August 5, 2011

Re: 120 Baxter Boulevard – 111 B006 – R-5 – Permit #2011-07-1709  
17 Codman Street – 129 G011 – R-3 – Permit #2011-07-1712  
209 Stevens Avenue - 177 I010 – R-5 – Permit #2011-07-1708

Our office is in receipt of your three building permits, one for each property listed above. At this point the permits for 120 Baxter Boulevard and 17 Codman are on hold, and the permit for 209 Stevens Avenue is denied.

Drawn By: MA & SPR

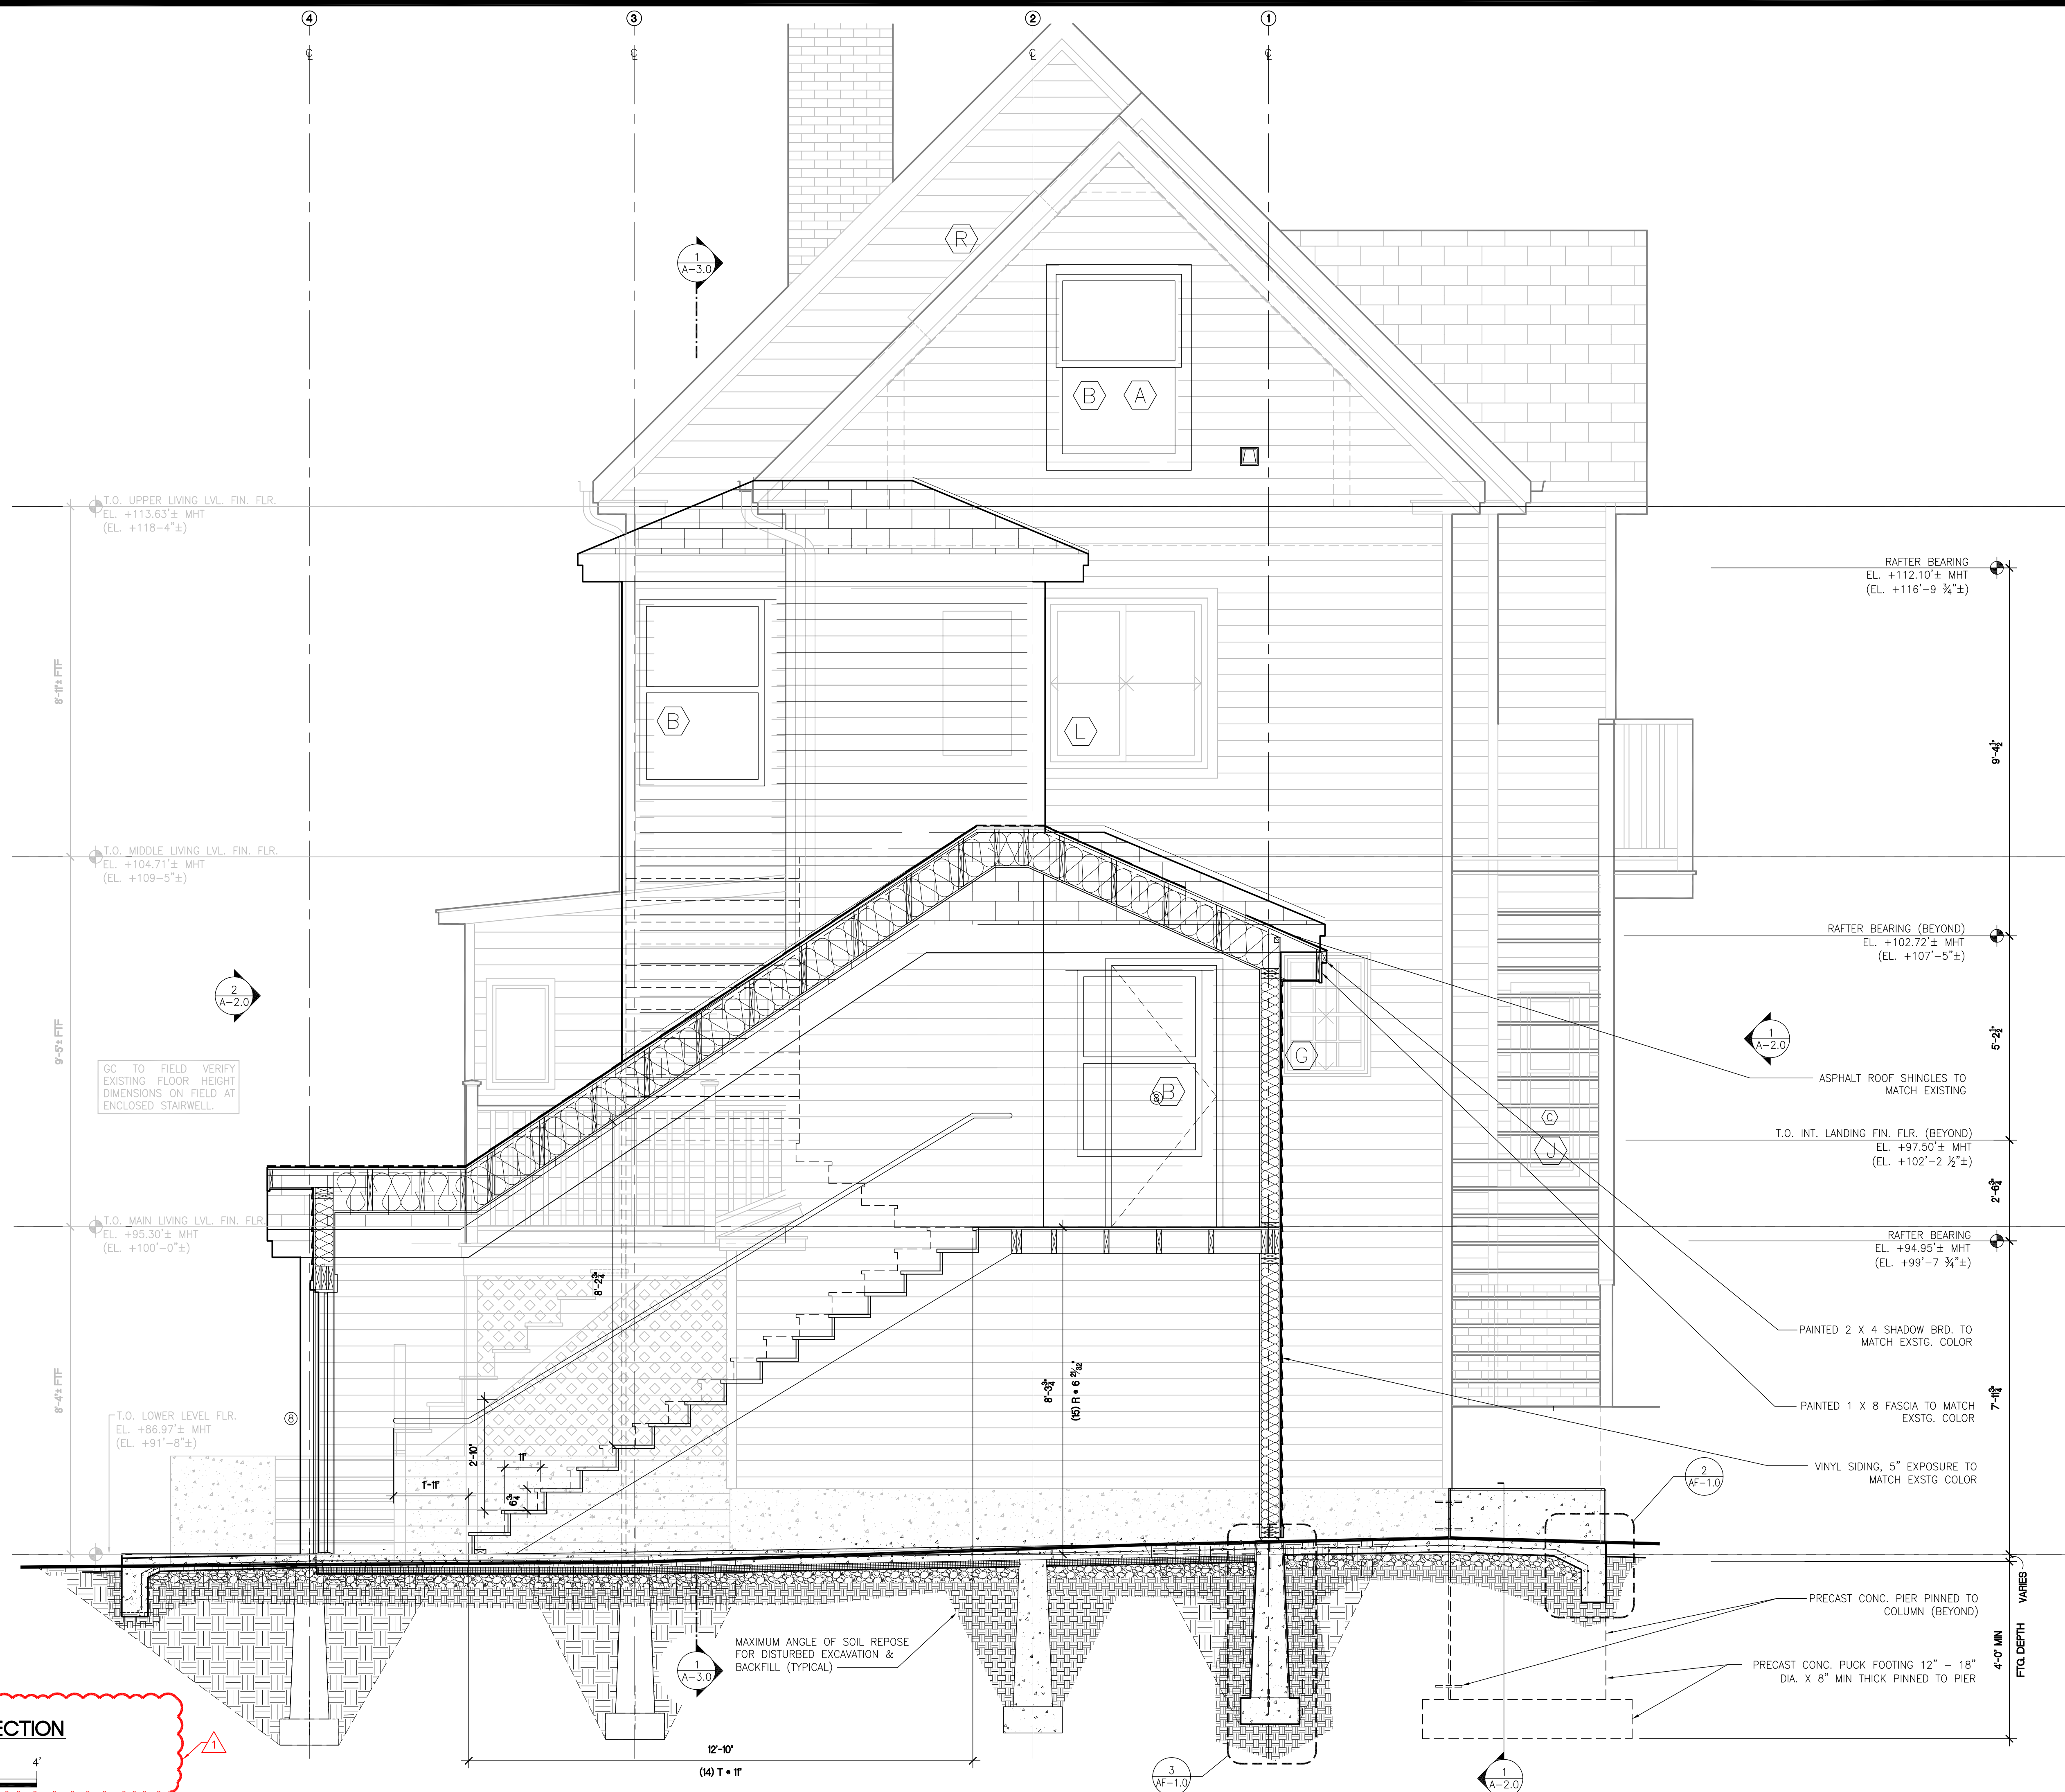
This permit is denied. Part of the application is to build an exterior stair from the second floor to the ground as a means of egress. This is a four family dwelling in the R-5 residential zone. Section 14-117(a)(2)(c) states that "no open outside stairways or fire escapes above the ground floor shall be constructed.". If a second means of egress is required, it must be constructed as a completely enclosed structure. You need to submit revised plans that show an enclosed stair that meets all the zoning requirements.
